Approval of reserved matters following outline consent WA/26/18/OUT for layout & scale for 6 No. dwellings & 6 No. detached garages.

Lanes End West Walberton Lane Walberton

Thank you for your internet representation made on 14th March 2019 which has been recorded as '**an objection**' with the comments as follows:

PLOTS 1 AND 2 FLOOR PLANS AND ELEVATIONS

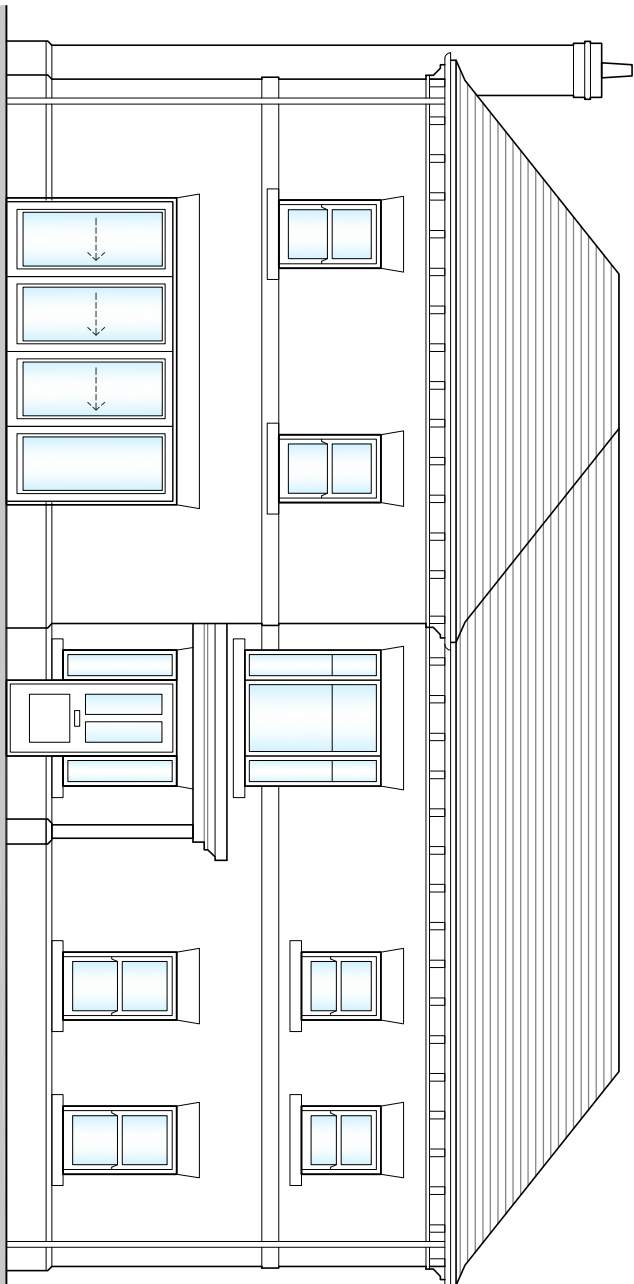
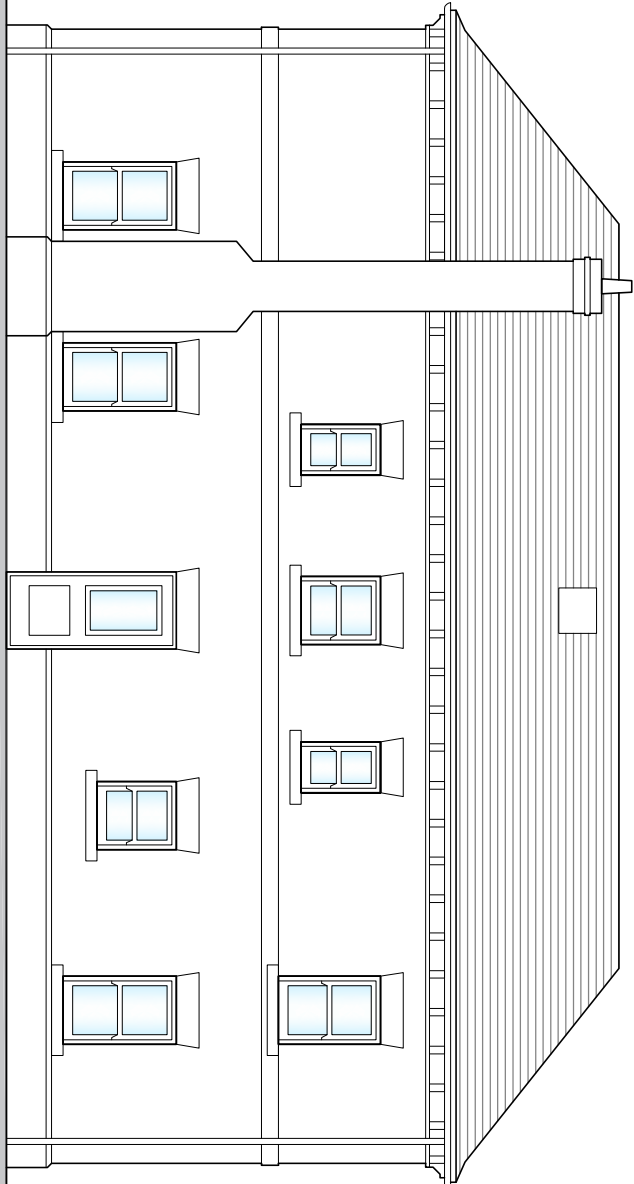
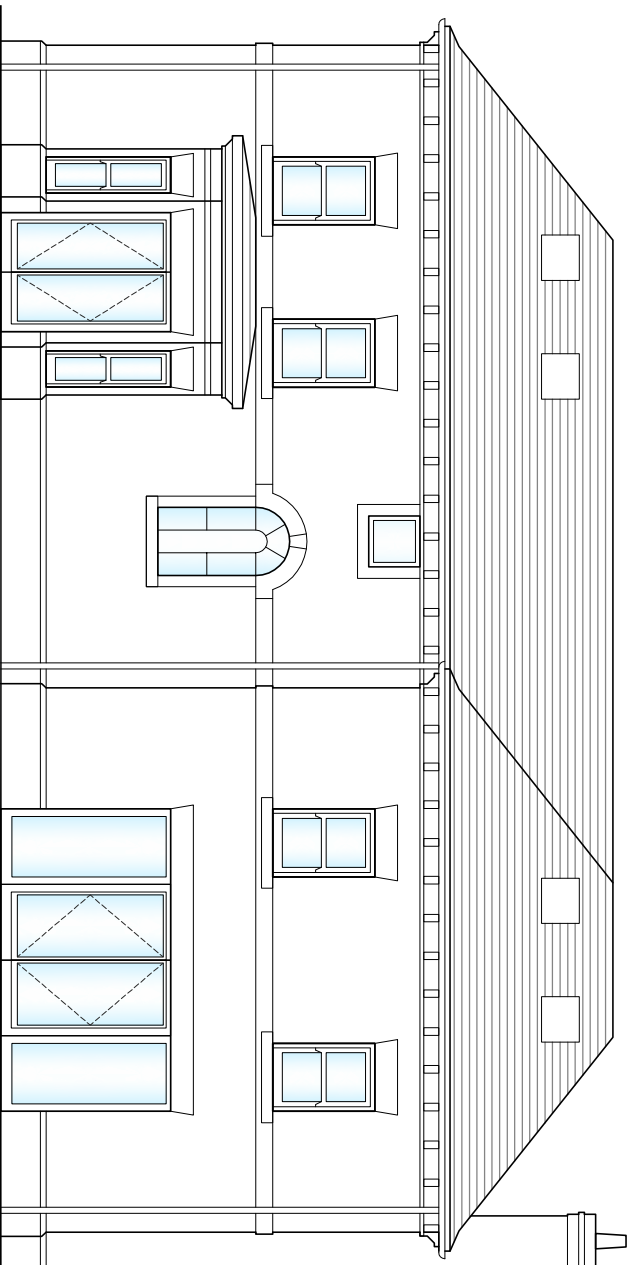
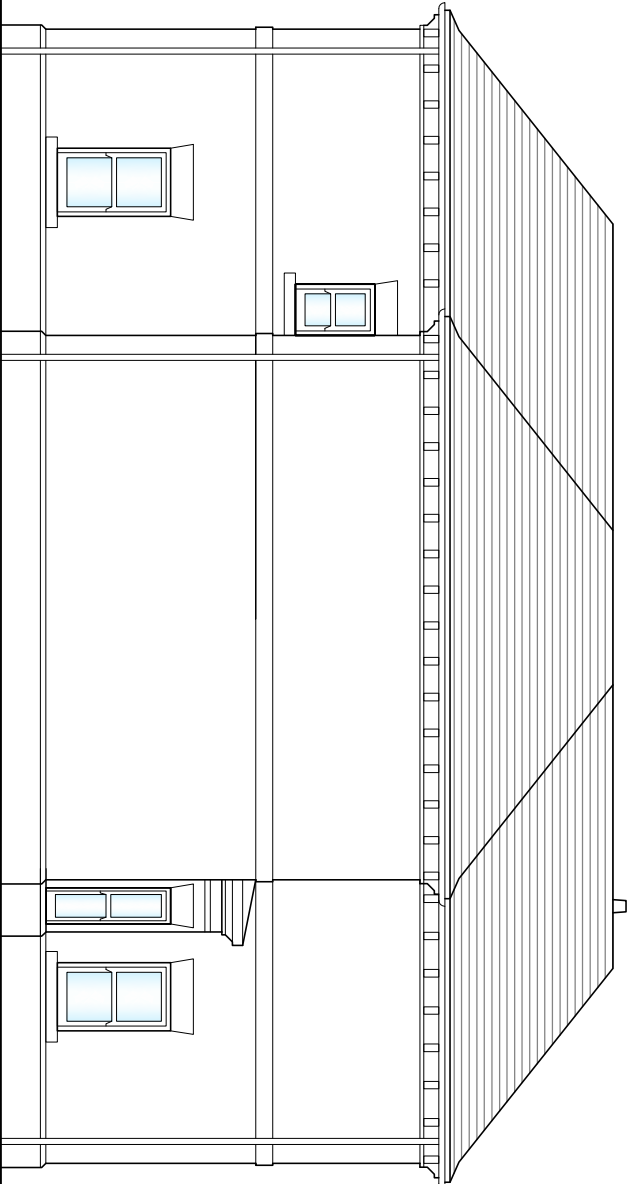
Additionally, the 3rd story will make the houses very overbearing and will have a significant impact on surrounding neighbour's views and privacy.

In my opinion any 3rd story windows facing properties outside the development should be removed as the bare minimum, really there should be less houses on this plot and they should not be as tall.
